Tuesday, 29 August 2023

**Subject: Response to Submission Report for the Narwee Parklands Care Community State Significant Development Application (SSD-45024776)
59-67 Karne Street North, Narwee**

1 SIGNAGE PROVISION (S1)

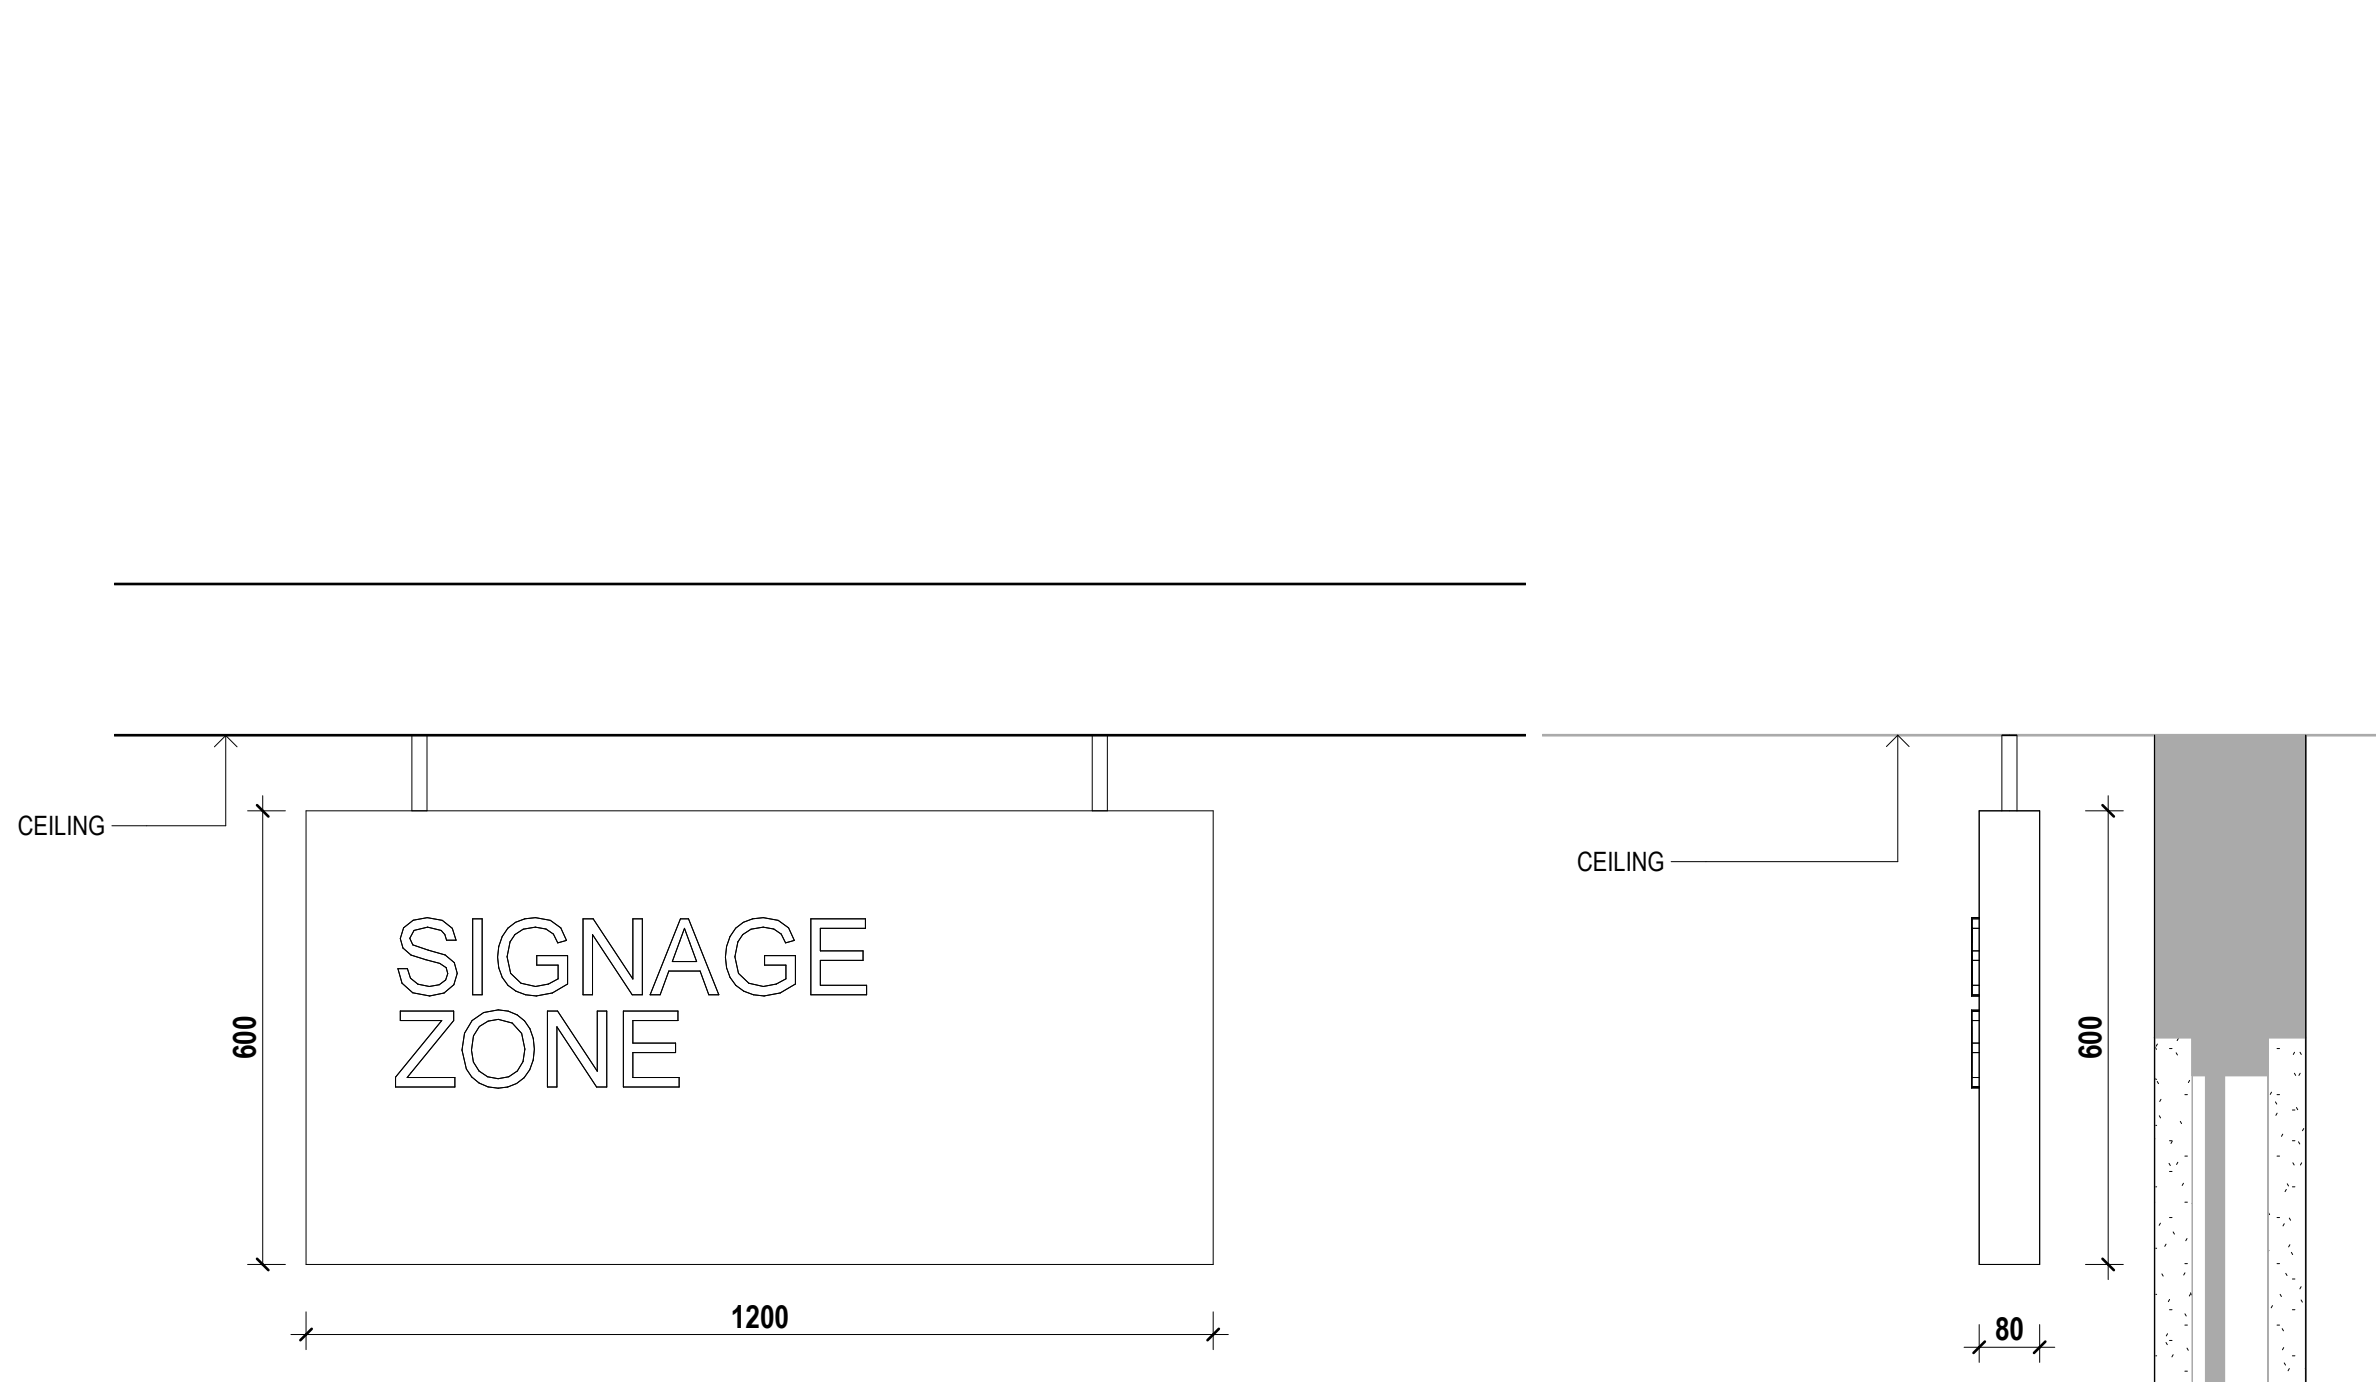
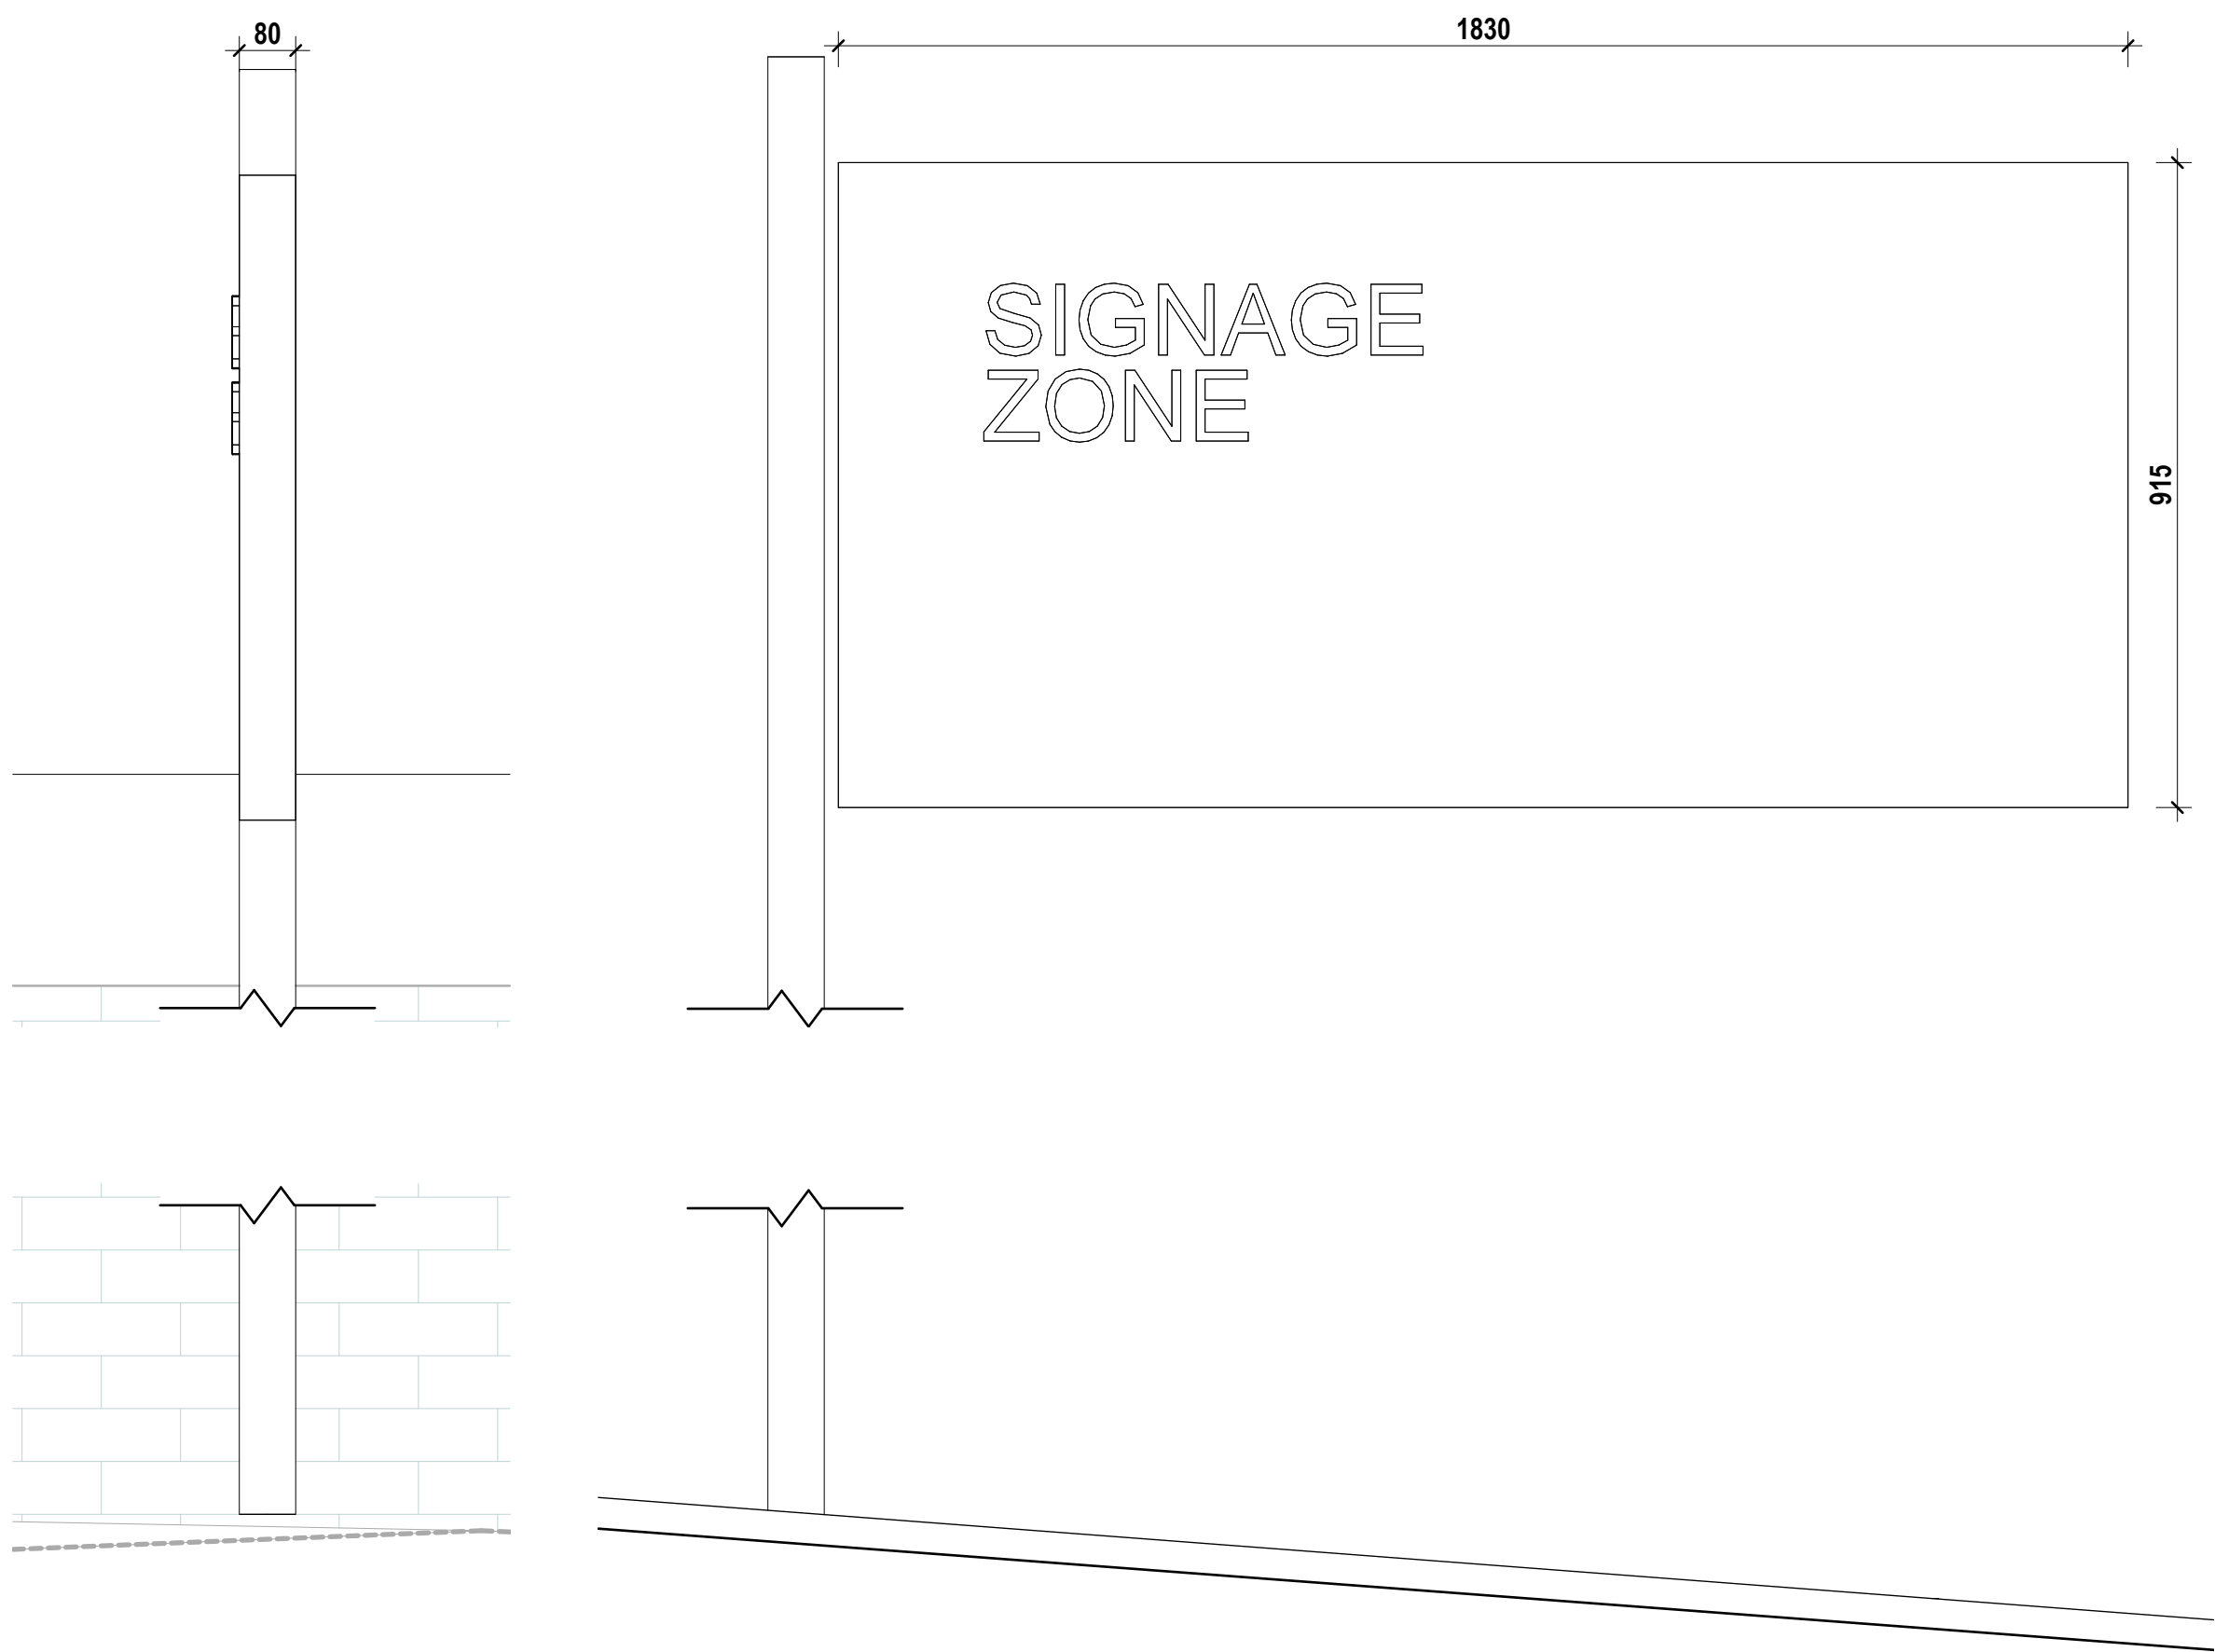
GSA / EU	(a) Clarification is sought on the location of business identification and wayfinding signage as there are inconsistencies between the Environmental Impact Statement (EIS), elevations and floor plans. Particularly, the EIS states 4x business identification signs are to be located on the western elevation. However, the architectural plans demonstrate signs 01 and 04 on the northern elevation and 2x sign 02's on the western elevation. Furthermore, sign 04 is not indicated on the northern elevation plan and the western elevation plan demonstrates 3x signs, while the floor plans only show 2x signs.	Northern Elevation - Signage S1 & S4. Both non-illuminated. Western Elevation - Signage S2 x 2nos & S3-A (illuminated) + S3-B (illuminated)	Refer to DA2001[F] DA6200[C] DA6201[A]
GSA	(c) Elevations of fencing across the entirety of the site are to be provided.	Fencing elevation provided.	Refer to DA3010[A]
